Urban Design Review Panel Report

Project: 254 Argyle Avenue
Hearing Date: October 6th, 2023
Comments Received: October 31st, 2023
Date: September 11, 2024

Project: 254 Argyle Avenue

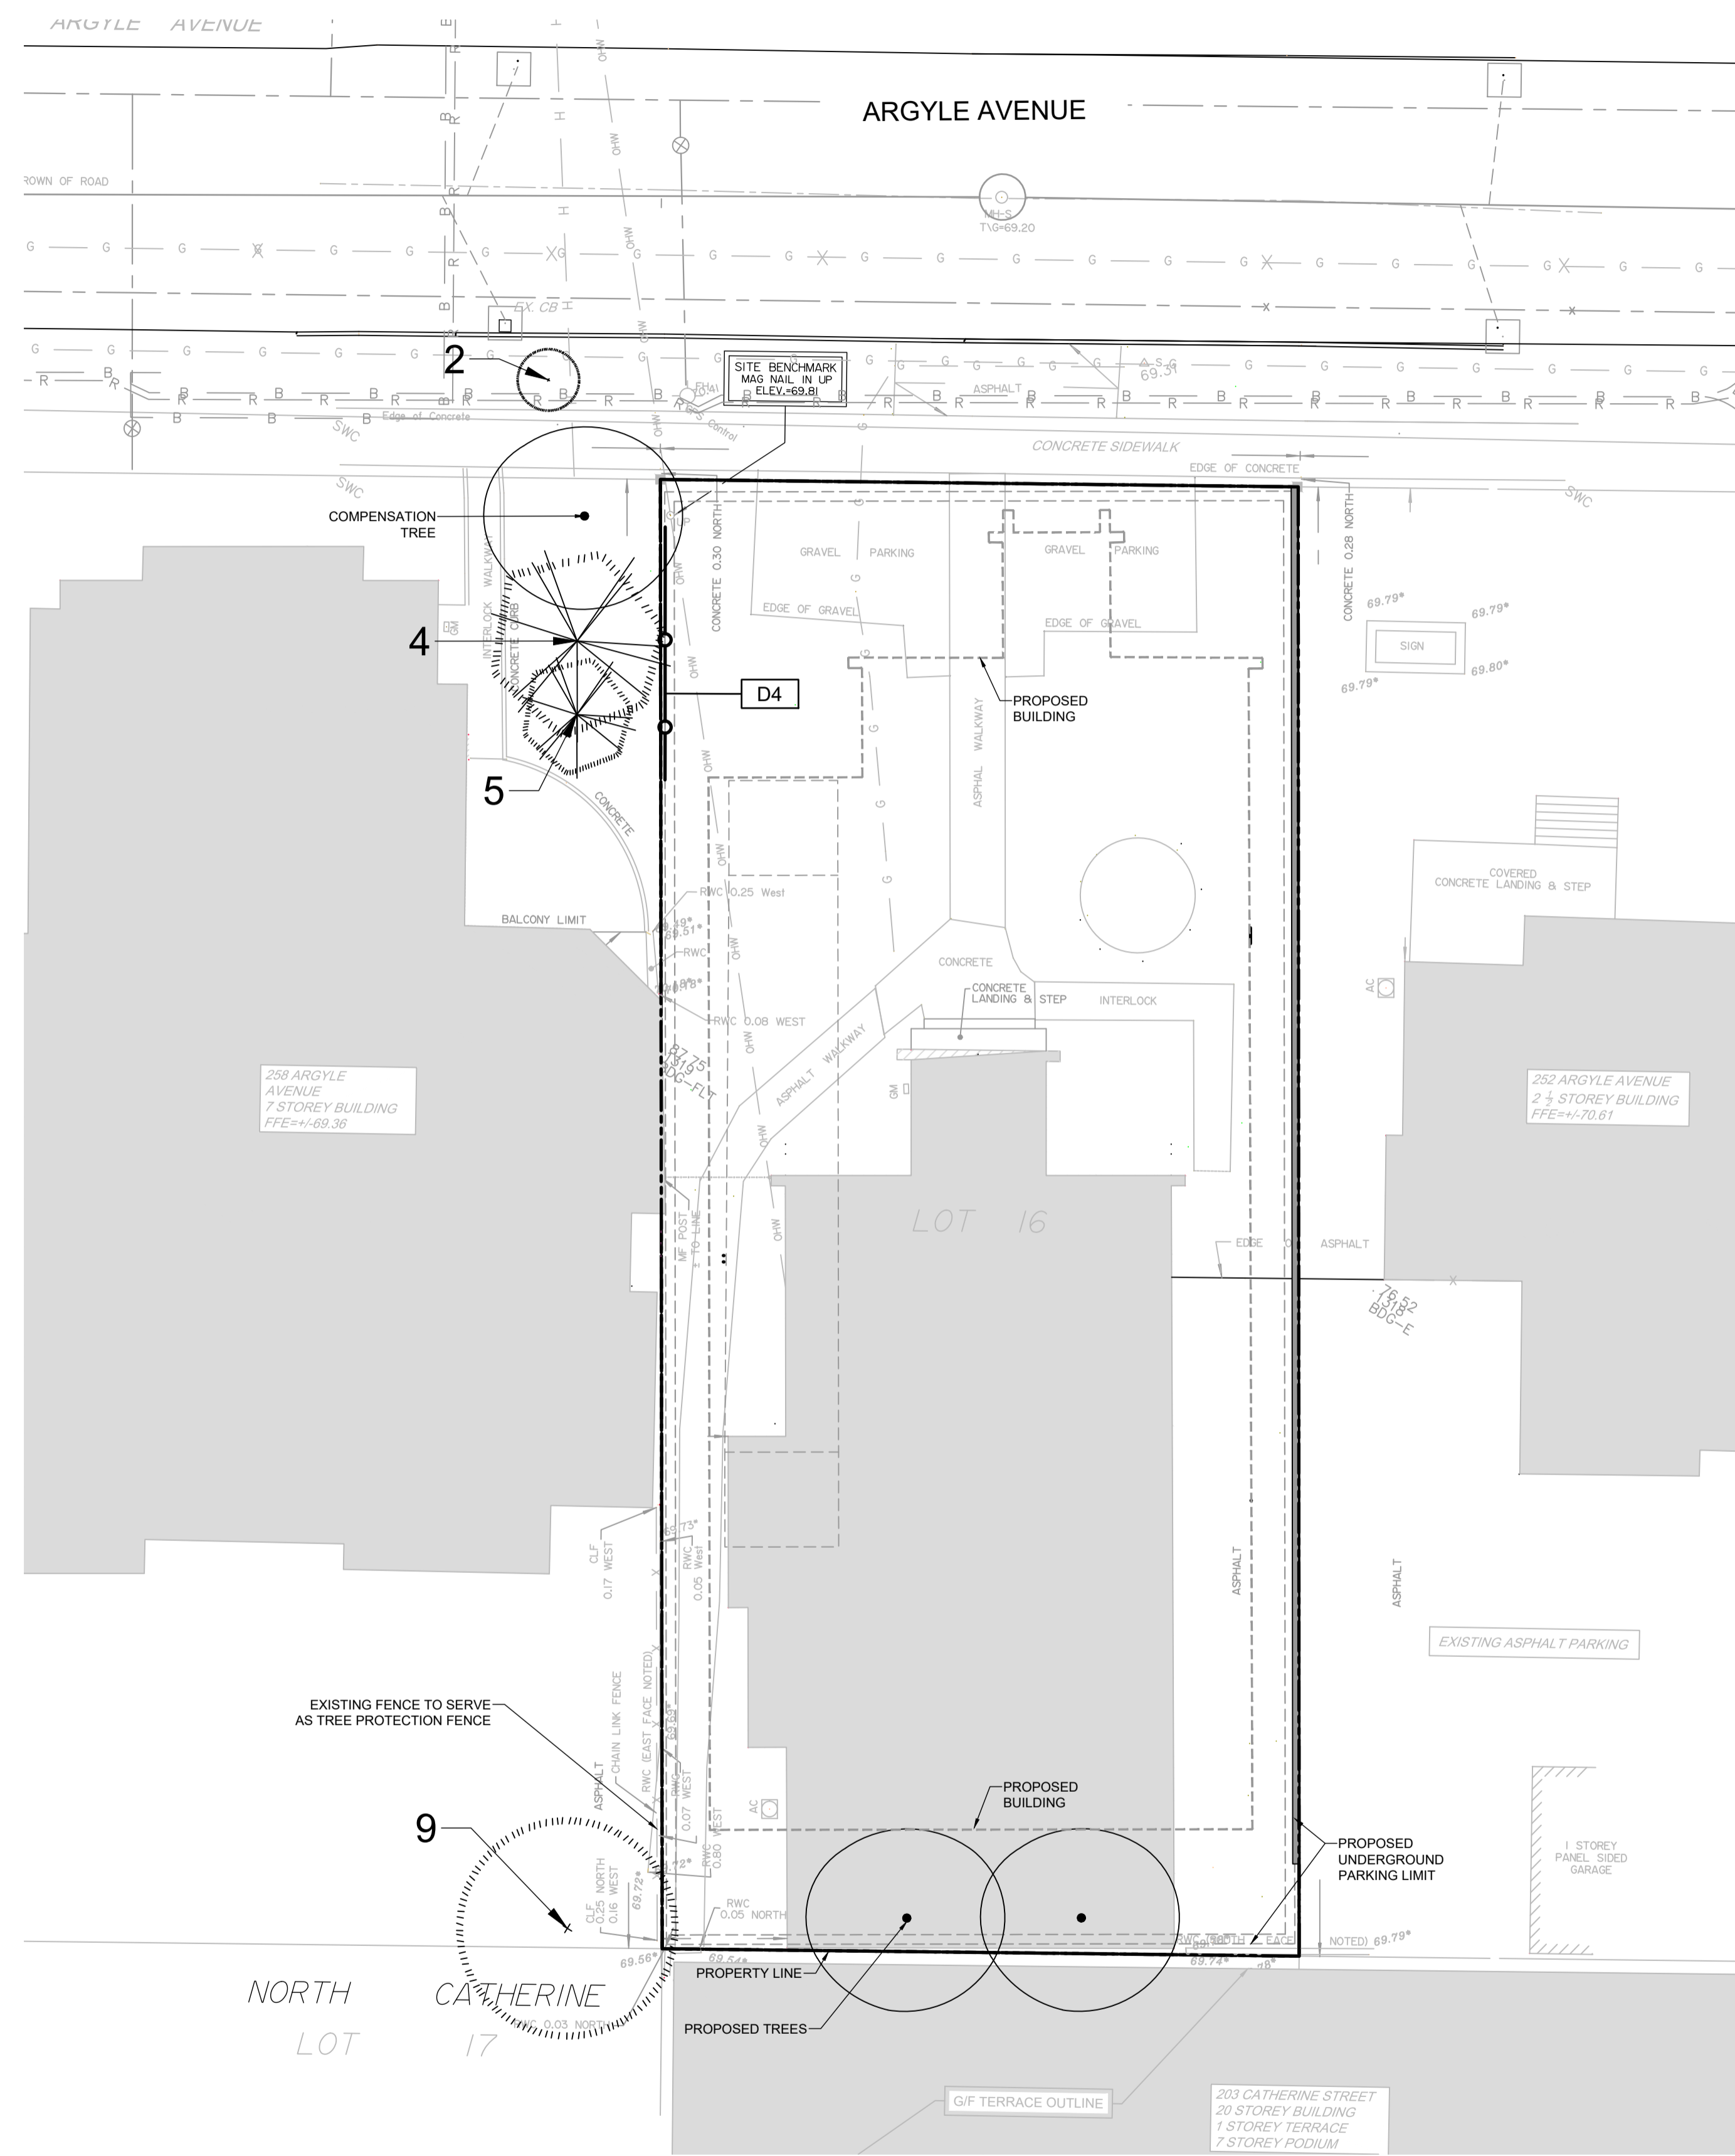
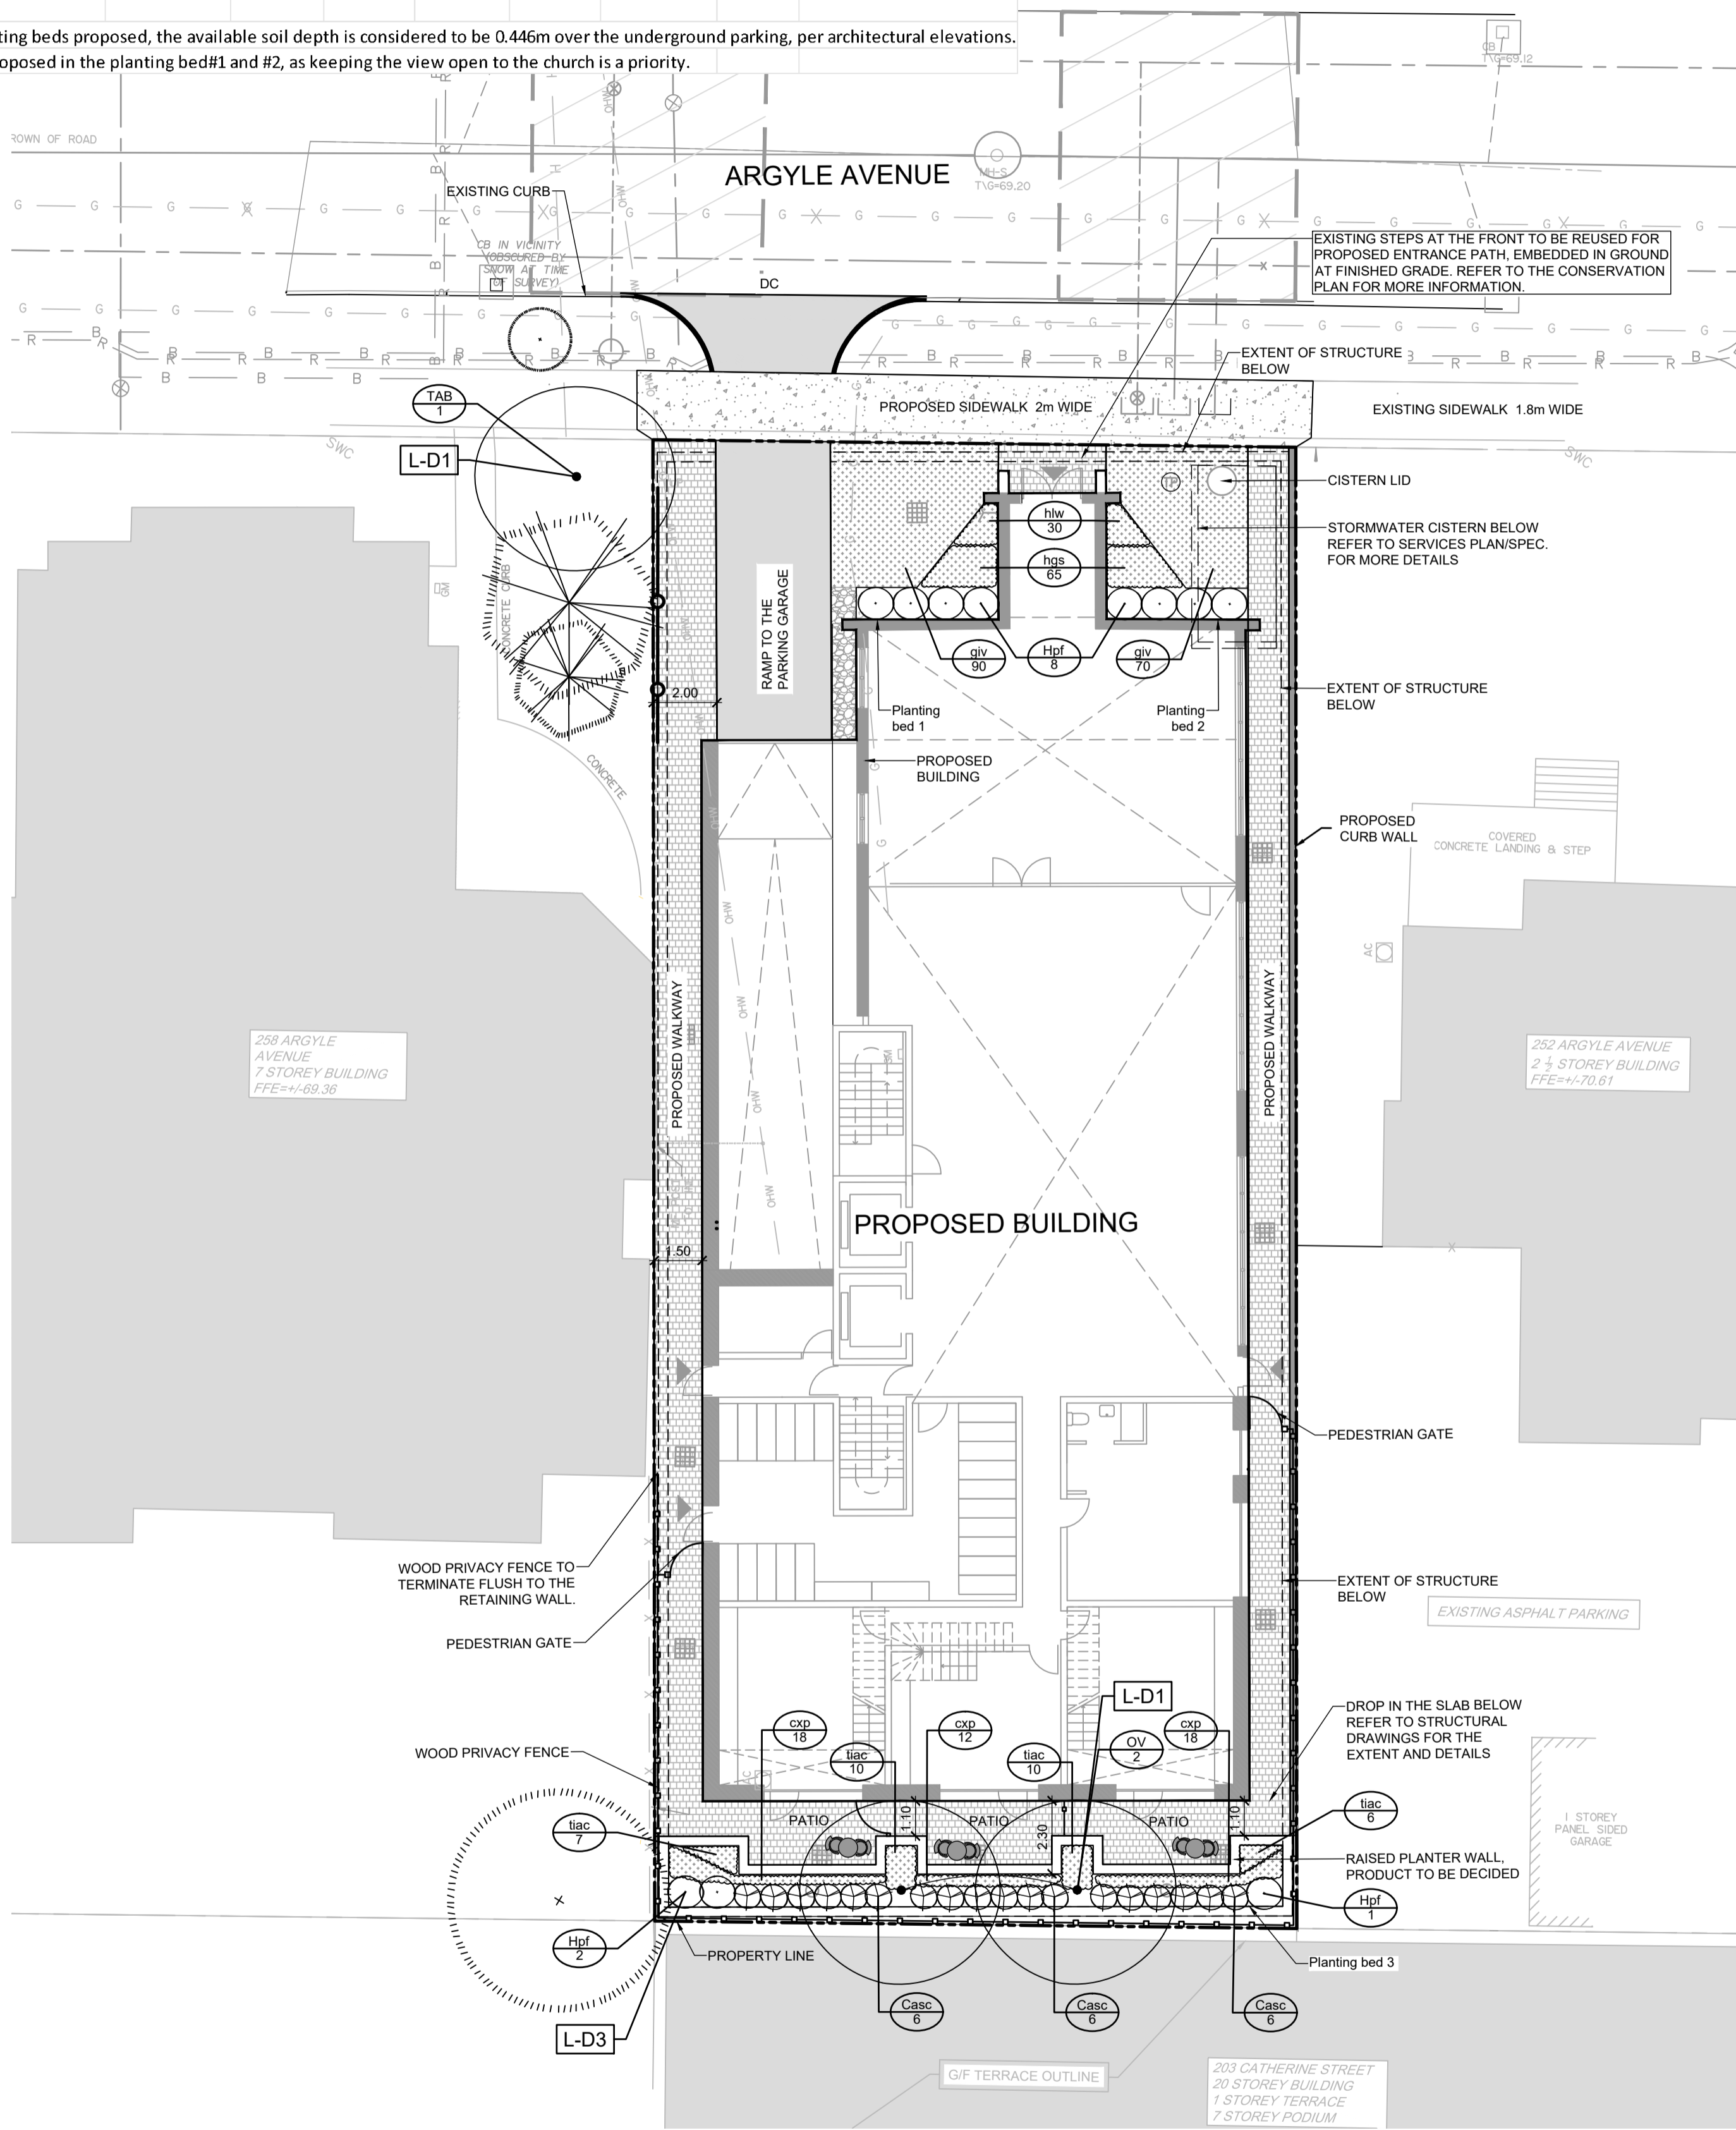
11. *The Panel appreciates the inclusion of two large trees on either side of the building entry.*
- *Ensure the trees are tall species with high canopies in order to not hide the heritage feature of the church.*
 - *Consider also providing street-trees in the boulevard space along Argyle Avenue.*

16. *The Panel recommends providing more of a ceremonial/historical landscape at the front of the building along Argyle Avenue.*

Response: Street trees were considered in the boulevard, which would be in keeping with the neighbourhood context. However, there is a gas line buried in the boulevard and street trees cannot be proposed without compromising guidelines relative to gas lines. Otherwise, planting in the front yard is based on the historical precedent for foundation planting. Hydrangea and daylily have been selected as plants that have been common favourites for a very long time and are suitable for the growing conditions of the site. Keeping the view open to the church is certainly a priority.

Response: Planting in the front is based on the historical precedent for foundation planting. Hydrangea and daylily have been selected as plants that have been common favourites for a very long time and are suitable for the growing conditions of the site. Keeping the view open to the church is certainly a priority.
